Please use the 2024 FAE Form found on: <https://planningdevelopment.elpasoco.com/planning-development-forms/#1584029763943-19bc4c03-3586>

EPC STORMWATER REVIEW COMMENTS IN ORANGE BOXES WITH BLACK TEXT

Town of Ramah WWTP Improvements Project

PCD File No. PPR-23-025

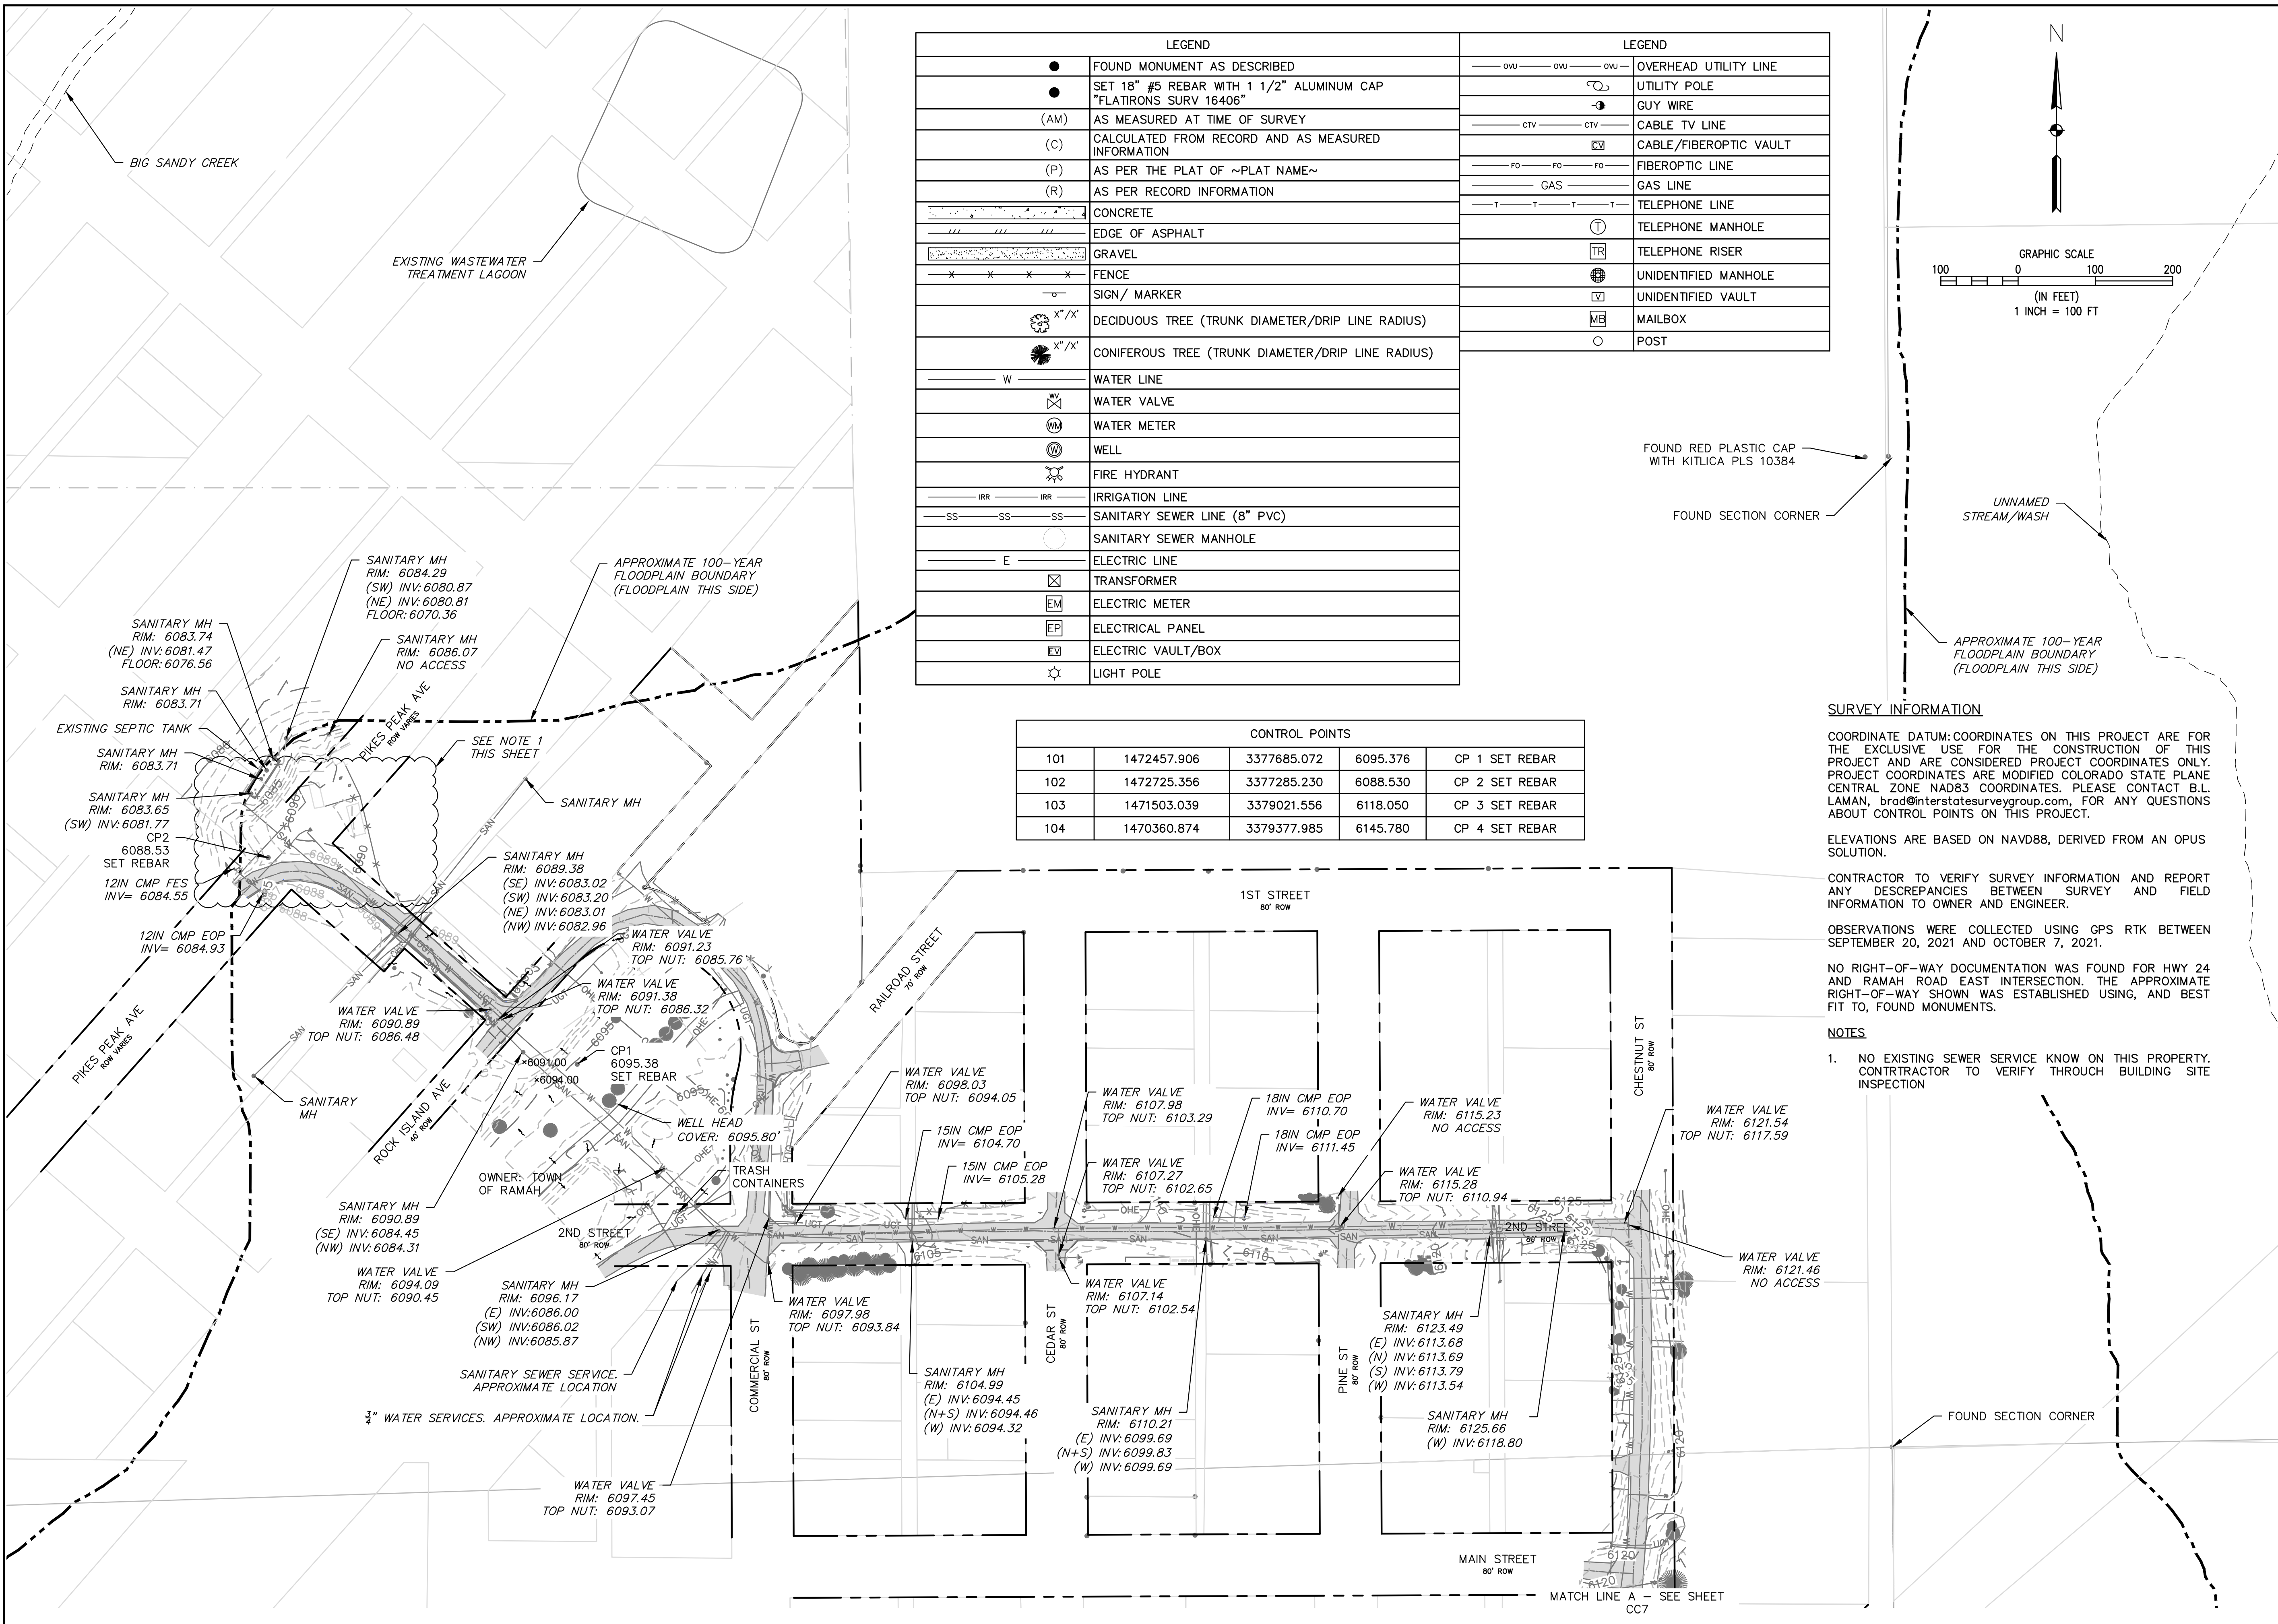
The total project site disturbs 17 acres. Permanent seeding should be more than 0.1 acre. All area within the limits of disturbance that does not have asphalt/gravel to stabilize should be seeded.
